Ribble Valley Borough Council
Housing & Development Control

Application no: **3/2021/0378**

Address: **Jersey Farm Knowsley Road Wilpshire Lancashire BB1 9PX**

Proposal: **Demolition of the existing stable structure and erection of a detached holiday cottage.**

**PROPOSED SITE PLAN**  
Scale 1:100

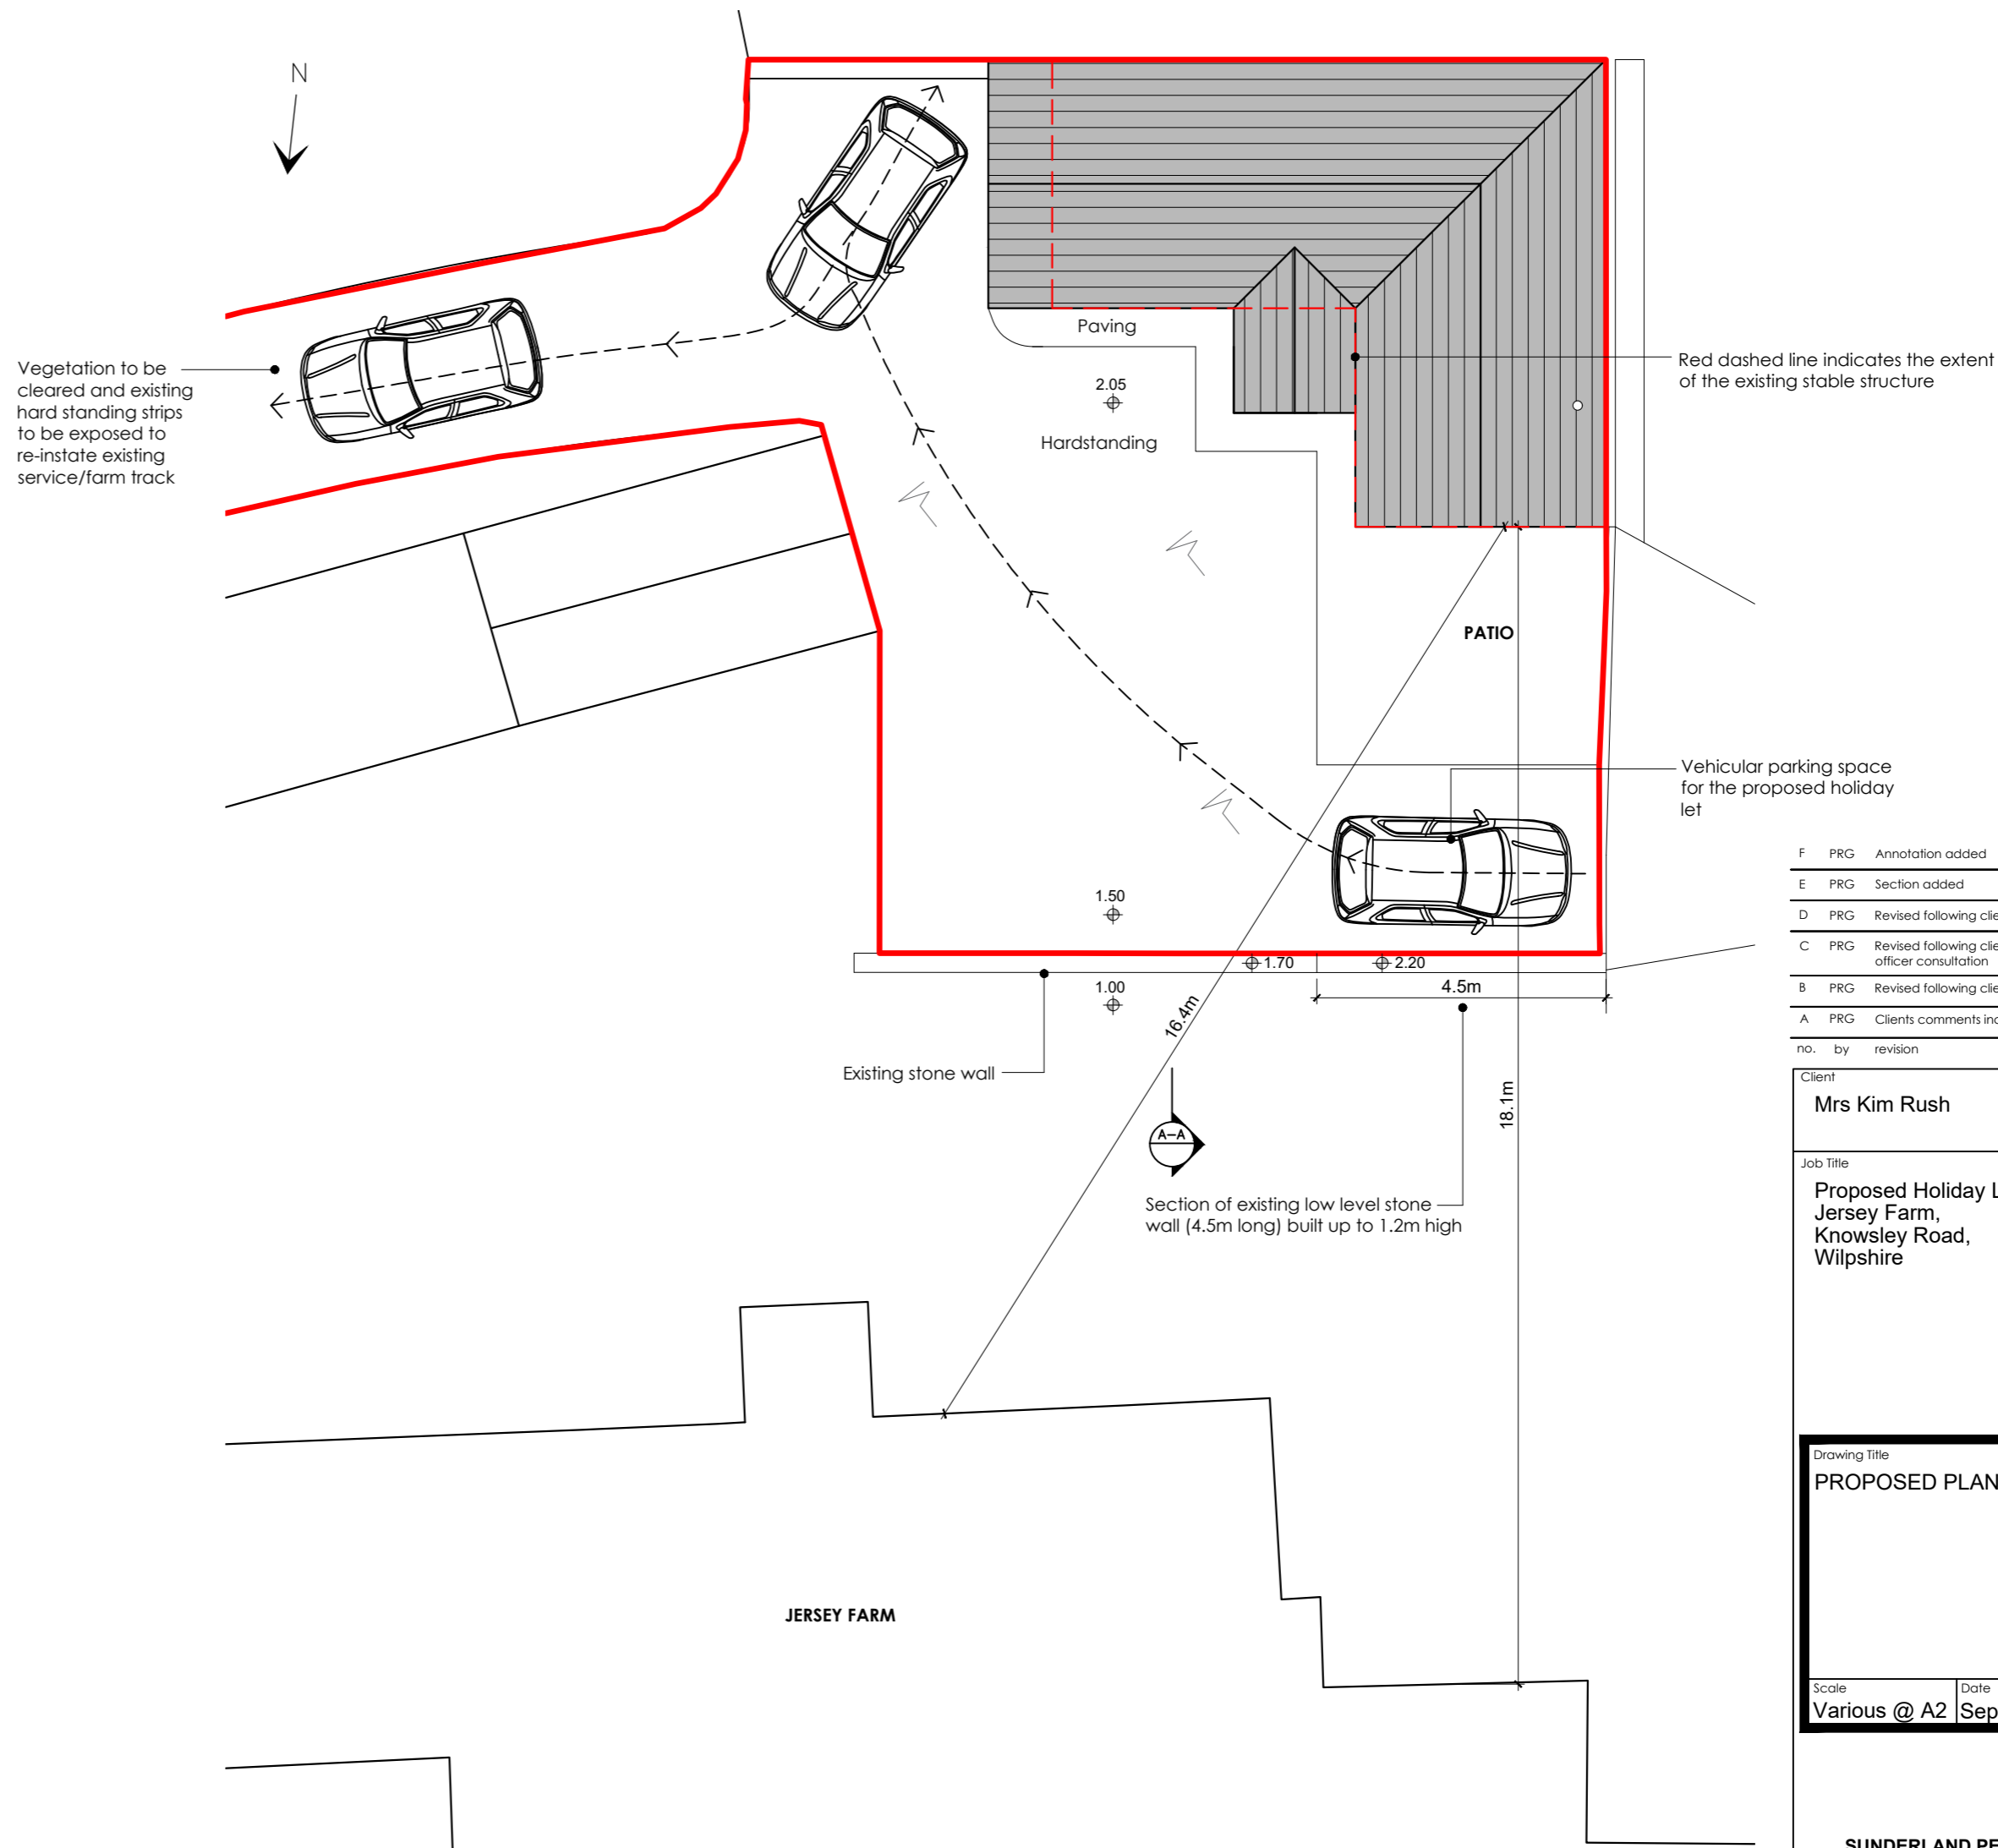
The LHA have reviewed SPA drawing number 6060-02 Rev F titled "Proposed Plans and Elevations" and understands the site will provide one car parking space for the one bed holiday cottage. This complies with the guidance set in the Joint Lancashire Structure Plan.

The Applicant has also provided a turning area to allow vehicles to emerge onto the highway in a forward gear. Therefore, the LHA have no objections to the proposal.

1. The development hereby permitted shall not be occupied until such time as the parking and turning facilities have been implemented in accordance with SPA drawing number 6060-02 Rev F. Thereafter the onsite parking provision shall be so maintained in perpetuity.
